23 November 2018

Contact: *Alison Kniha*
Telephone: *02 9865 2505*
Our ref: *D2018/128889*

SSD 7173 MOD 6 – Altis Warehouse and Logistics Hub – 585-649 Mamre Road Orchard Hills

JOB TITLE PLAN OF PROPOSED SUBDIVISION OF LOT 8 DP271141 ERSKINE PARK			Plan No.: 73535.008 VER 7
Reduction Ratio: 1:3000	Date of Survey: N/A	Surveyor: GKO Drawn By: SHL	Sheet 2 of 2

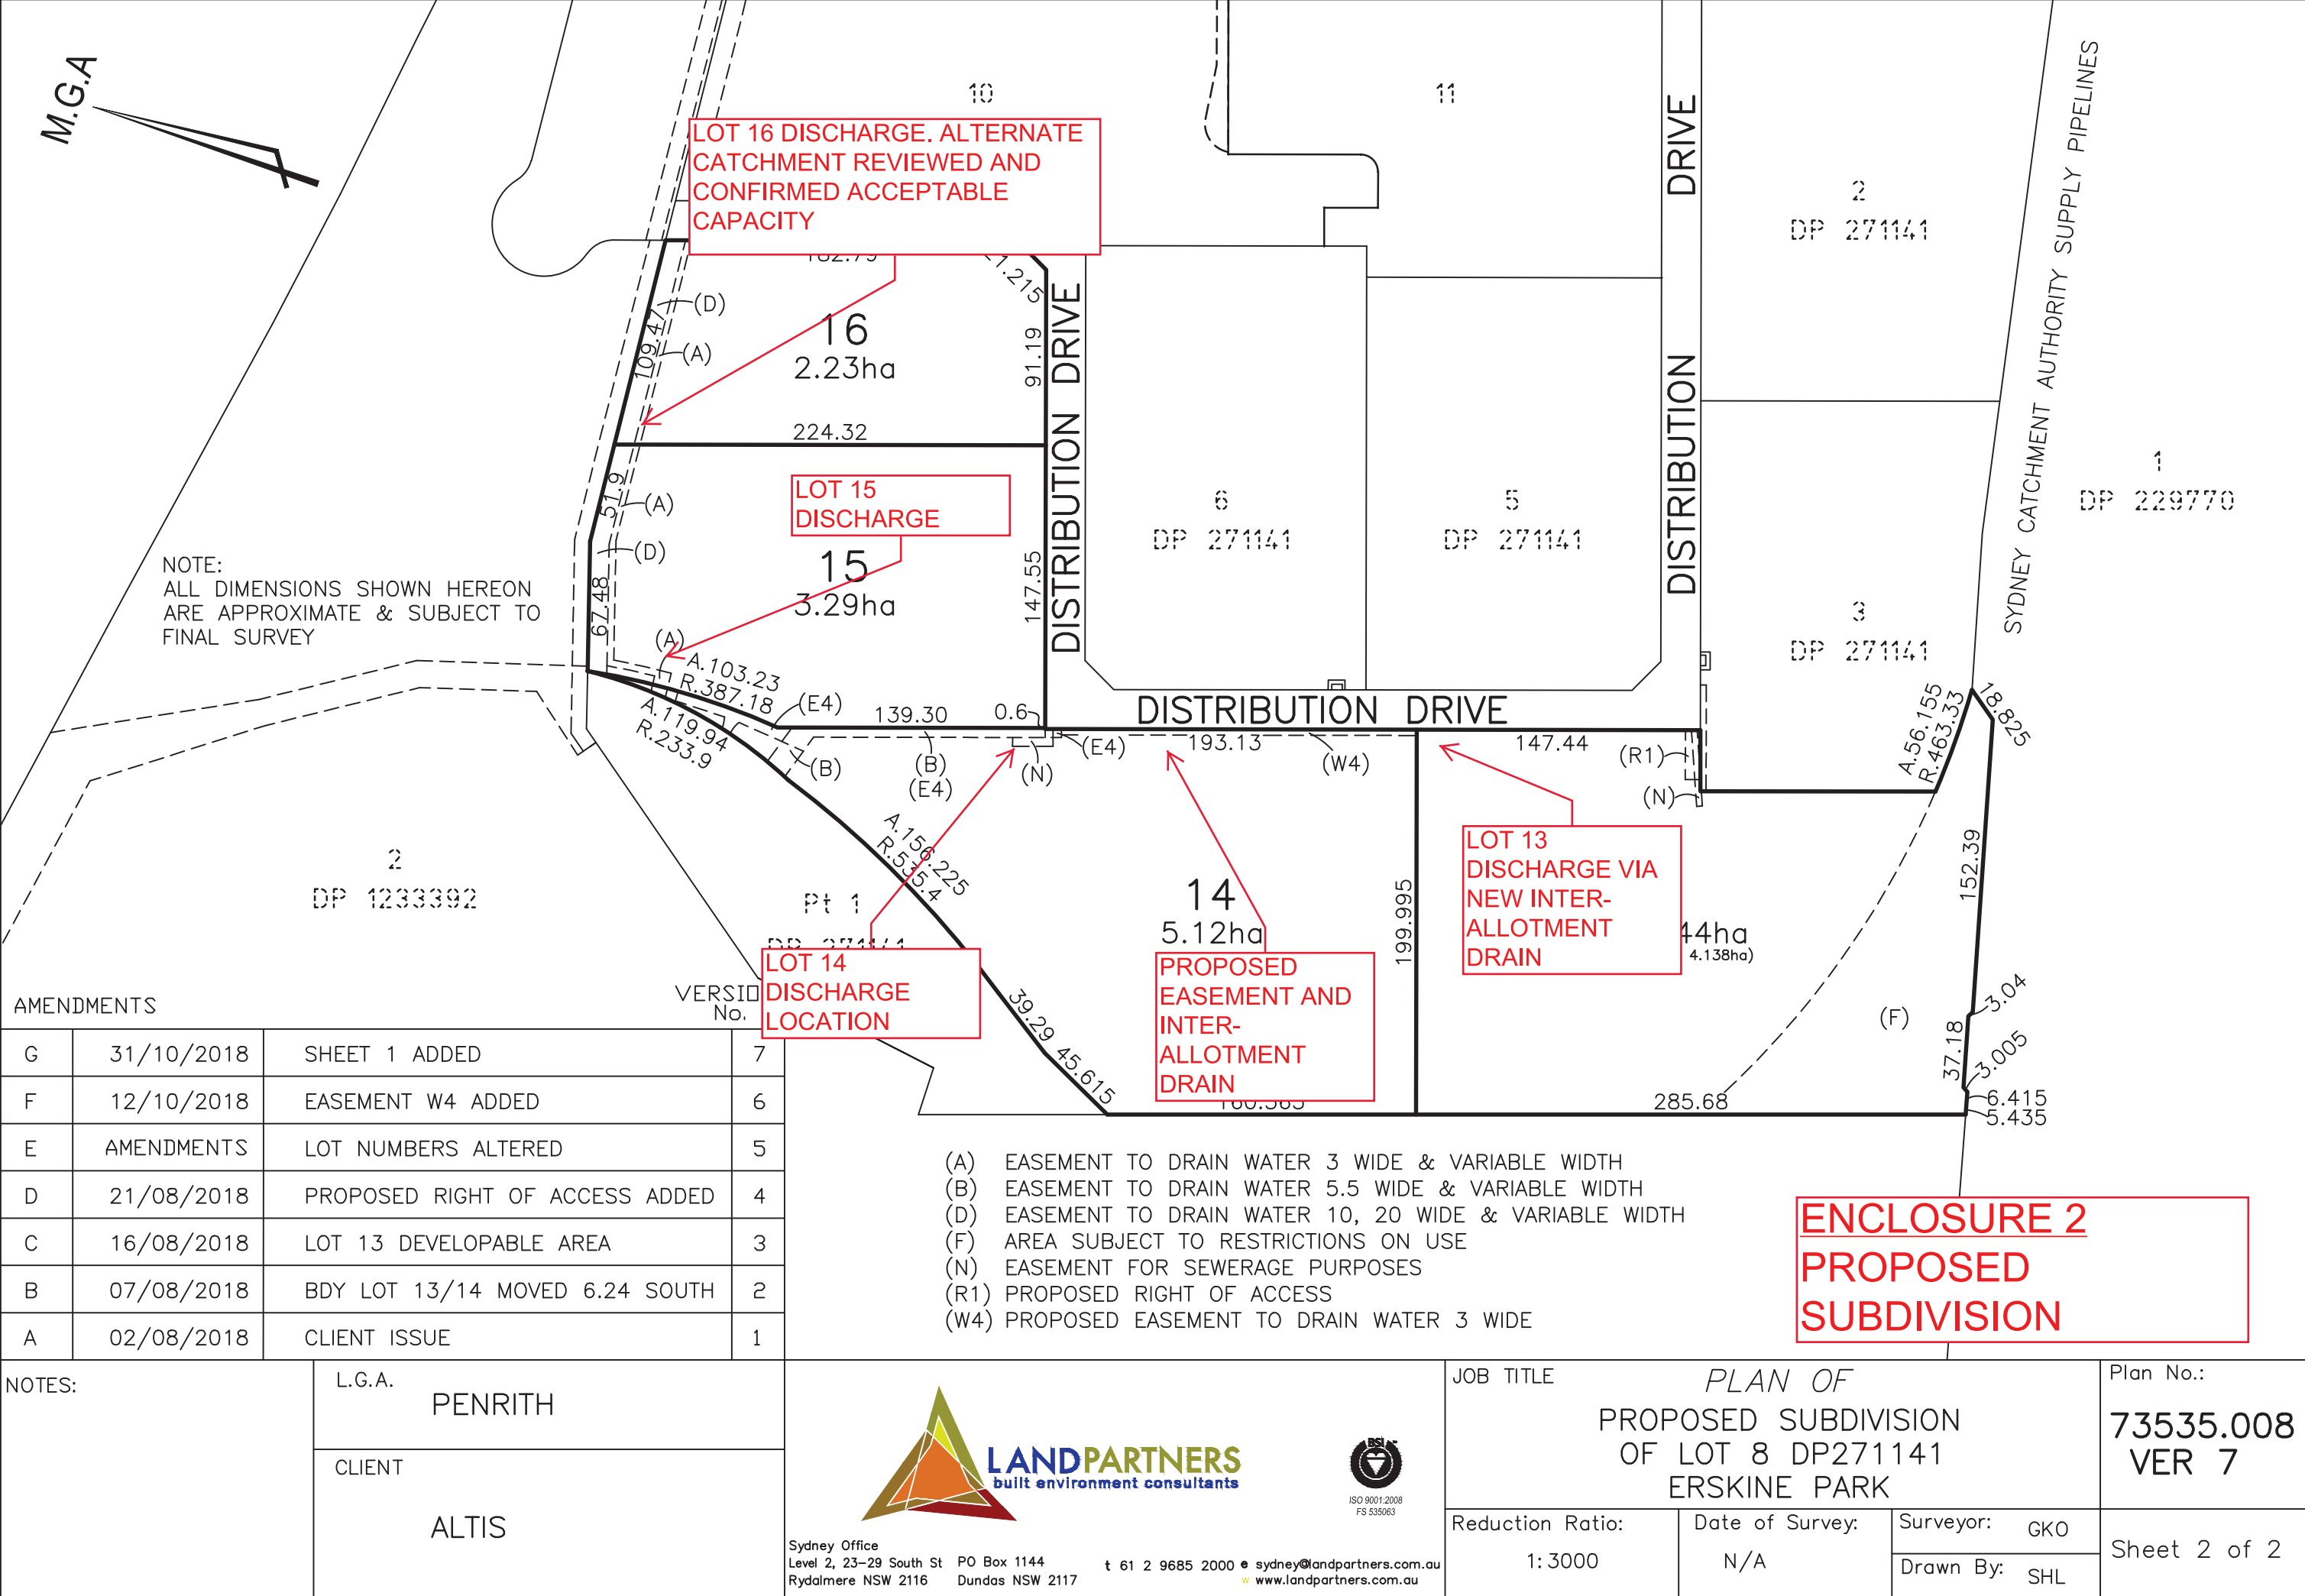
For this Modification (MOD 6) it is noted all stormwater management outcomes will be generally consistent with that approved under SSD 7173. It is important these conditions are fully implemented in the areas immediately adjacent to the Pipelines corridor, and the area notated (F) on the amended subdivision plan (Sheet 2; Plan No. 73535.008 Ver 7; 31/10/2018) continues to be identified as being restricted in use.
